**KIRKLEES METROPOLITAN COUNCIL
INVESTMENT & REGENERATION SERVICE**

DELEGATED DECISION TO DETERMINE PLANNING APPLICATIONS

Reference No:	2023/62/91140/W
Site Address:	Park Views, 72, Beaumont Park Road, Beaumont Park, Huddersfield, HD4 5JH
Description:	Erection of outbuilding / pergola
Recommending Officer:	Laura Yeadon

DECISION – REFUSED

Project Name 72 Beaumont Park Road, Beaumont Park, Huddersfield, HD4 5JH	
Drawing Title: Proposed Elevations-Pergola	
Drawing Number: TR-A23-0103-006	Scale: 1 : 100@A1
Date: 11/04/23	Revision:
Drawn By: AM	Checked by: JA
Reason For Issue: Planning

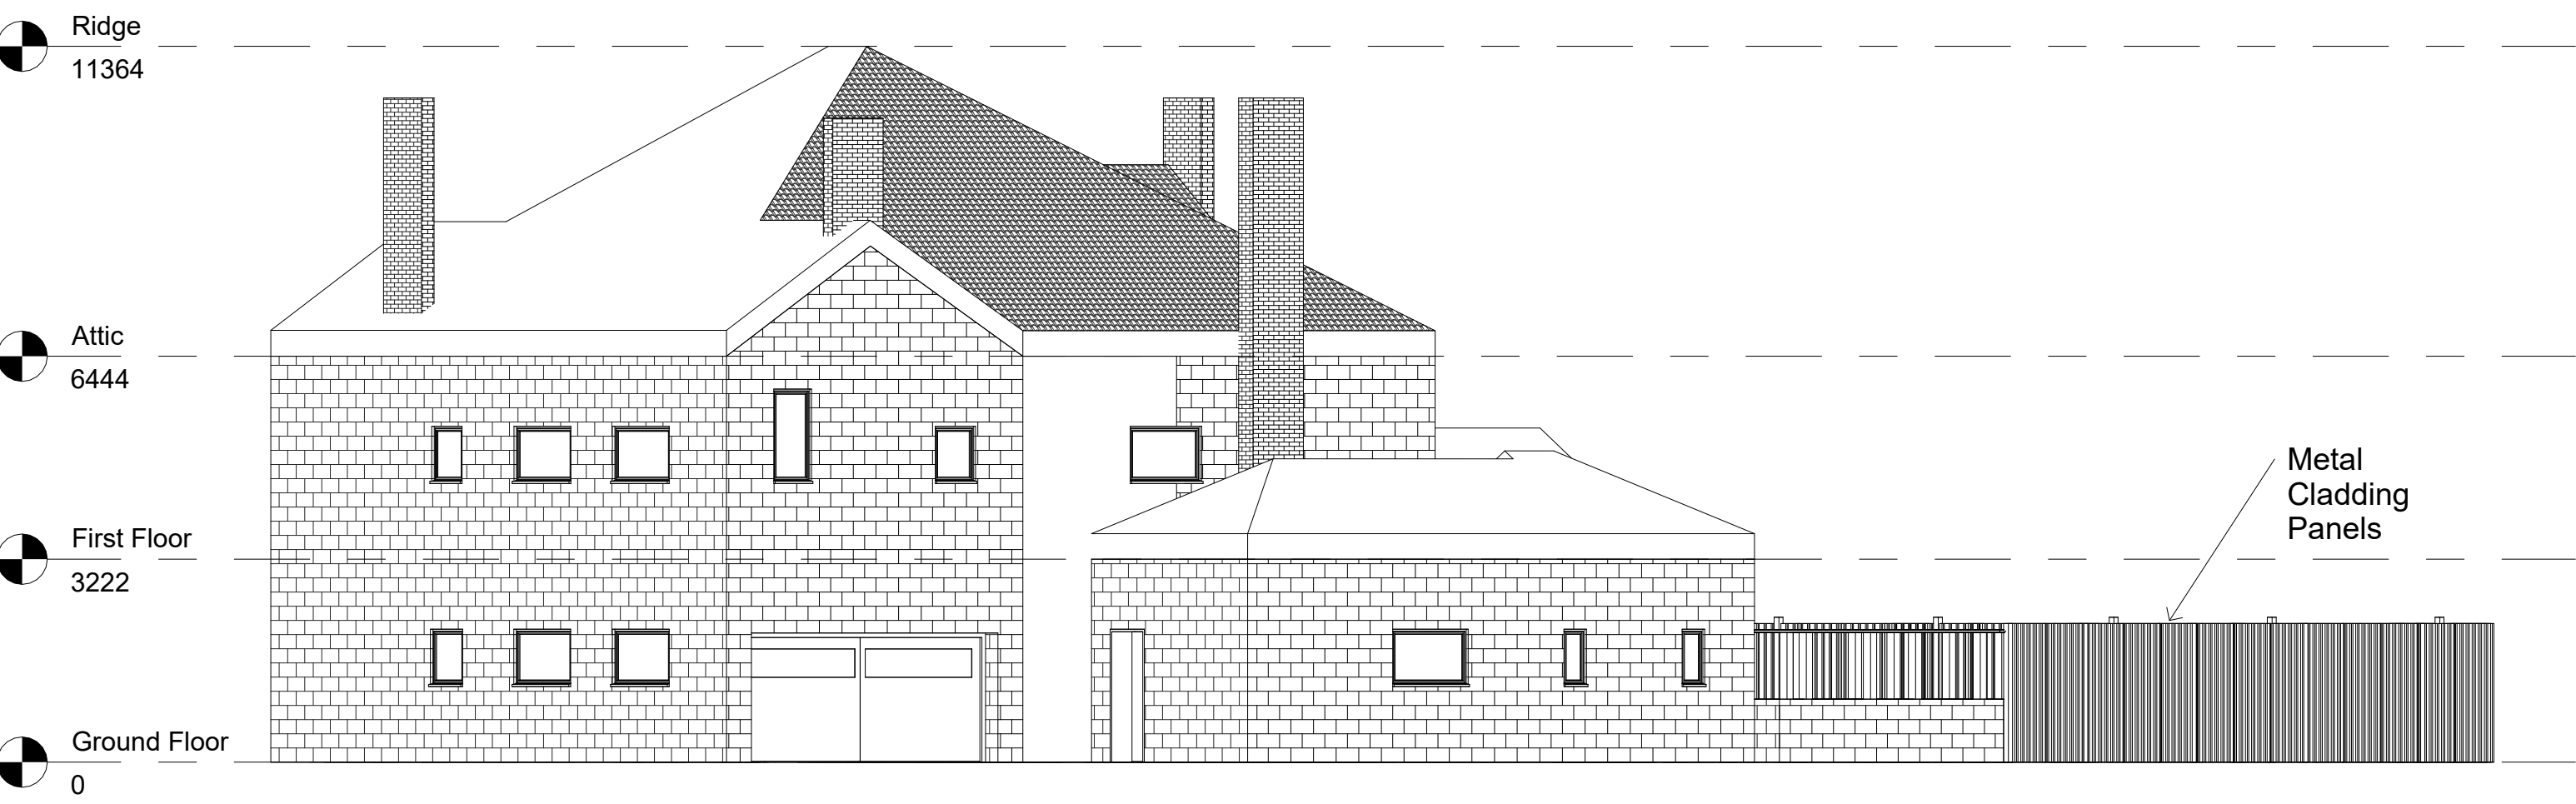
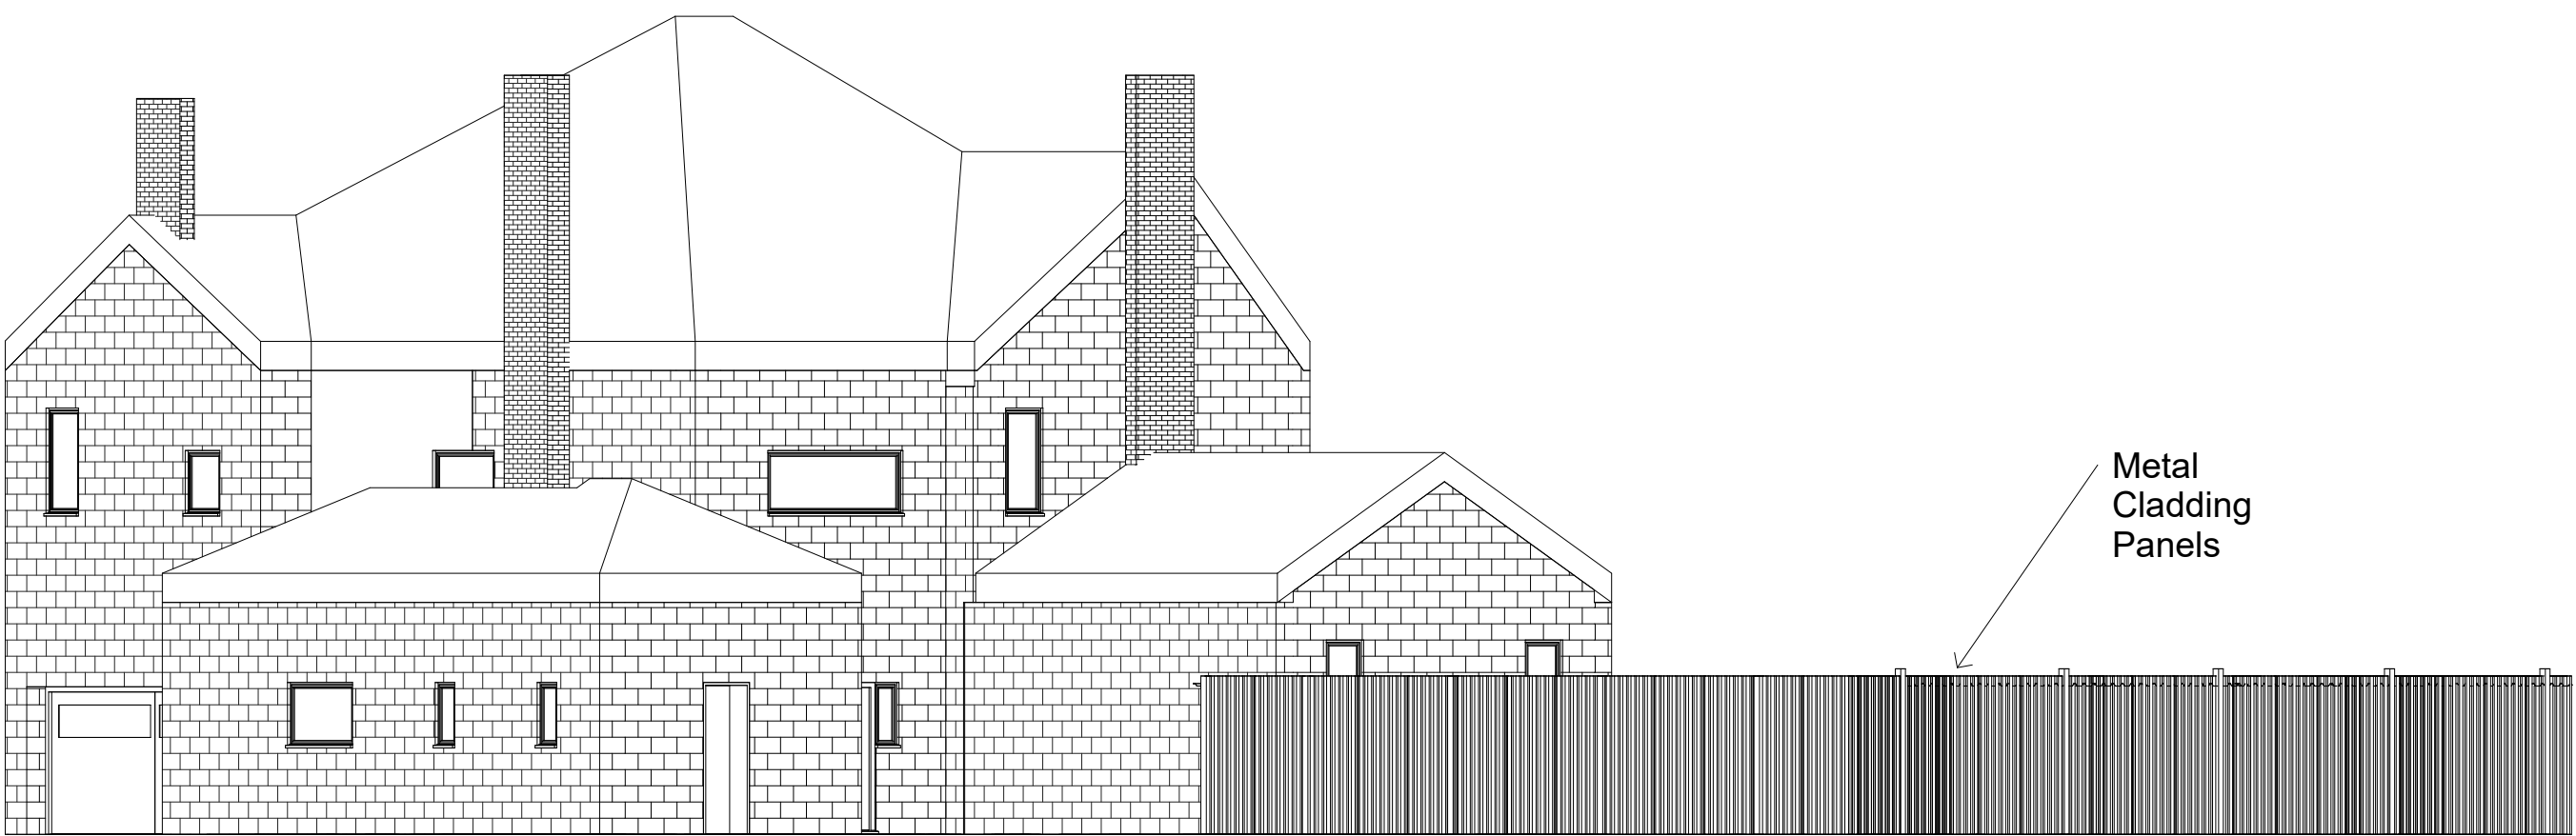
The application is for the erection of an outbuilding/pergola which is a detached structure and located to the side and forward of the host property. The materials are metal clad panels to the walls and roof.

The outbuilding/pergola is 'L' shaped with the following dimensions:

- 15.3m in depth
- 12 metres in maximum width
- 2.5m in overall height

As there have been no proposed amendments to the structure from the previously refused application, the matters within the previous refusal relating to siting, overall scale and being incongruous are not considered to have been overcome. The construction materials of the outbuilding/pergola are considered wholly inappropriate and it does not appear that there are any similar extensions in the immediate area of comparable size, scale, design or construction materials which would provide towards any level of justification for the extension in this case.

1. The outbuilding/pergola by virtue of its siting, overall scale, being incongruous and with low-quality construction materials results in a development that fails to sympathetically harmonise with the host dwelling and constitutes poor design. The development therefore causes detrimental harm to the host property and the wider character and appearance of the area, contrary to Key Design Principles 1, 2 and 9 of
